Date: 20/08/2018

Hurlstone Agricultural High School (SSD 17_8614): Response to Submissions

Response to Agency Submissions

Figure 7 – Pre Development Indicative Depths of Inundation & 1% AEP Flood Contours

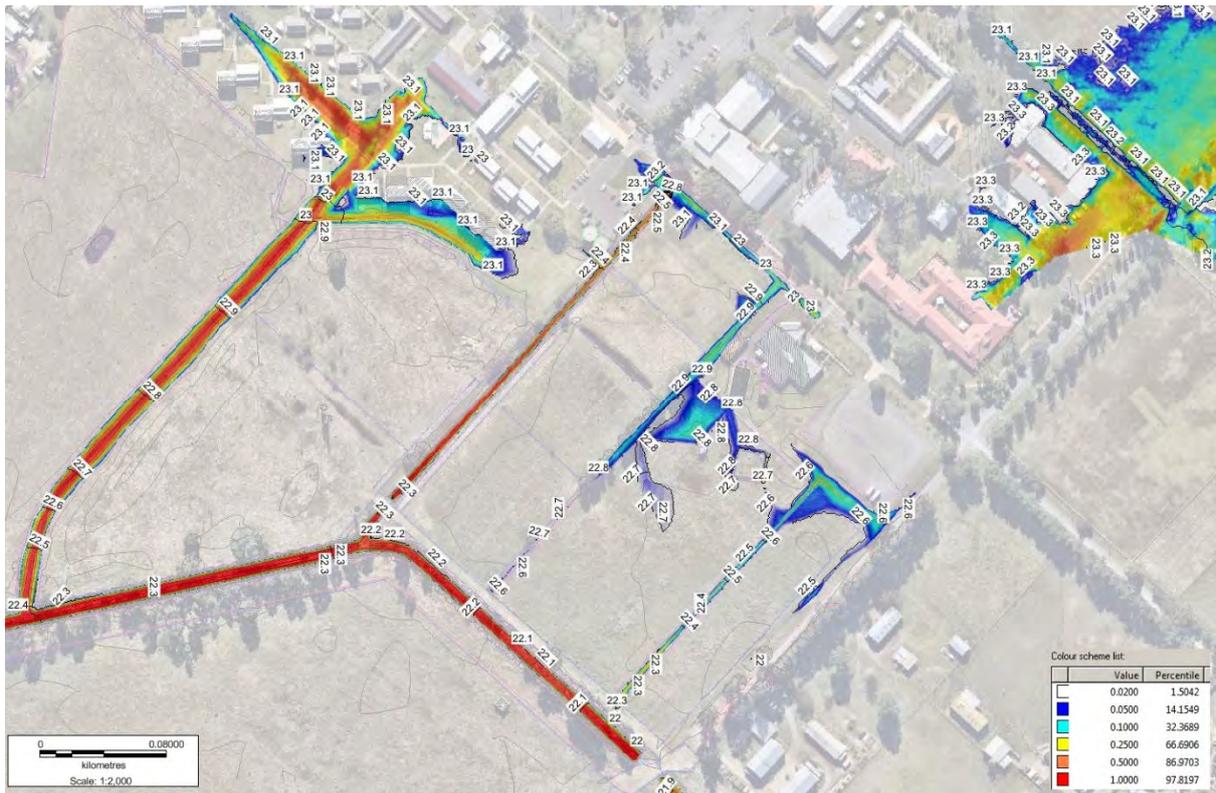
Issues Raised by Agency Submissions	Proponent's Response
	<p>especially a concern as the channels are piped underneath the buildings on the western side which provides an additional hazard.</p> <p>(b) Figure 7 (Pre-development) does not show the existing pipe from the university as shown in Figure 6. Clarification is sought on whether the pipe was modelled in the pre-development case. As the pipe is existing it should be include in the pre-development case.</p> <p>(c) The afflux map presented in Figure 9 is confusing to read. A legend should be on the figure as well as a simplification of how the afflux is presented. The text boxes with impact are confusing as to the exact location and the extent of the flood is hidden by these text boxes as well.</p> <p>(d) The assessment should provide a sensitivity analyses to determine the potential impacts from climate change on flooding behaviour, as per the flooding requirements issued in the SEARS for the proposal.</p>	considered necessary given the inland location of the property and distance from the coastline.
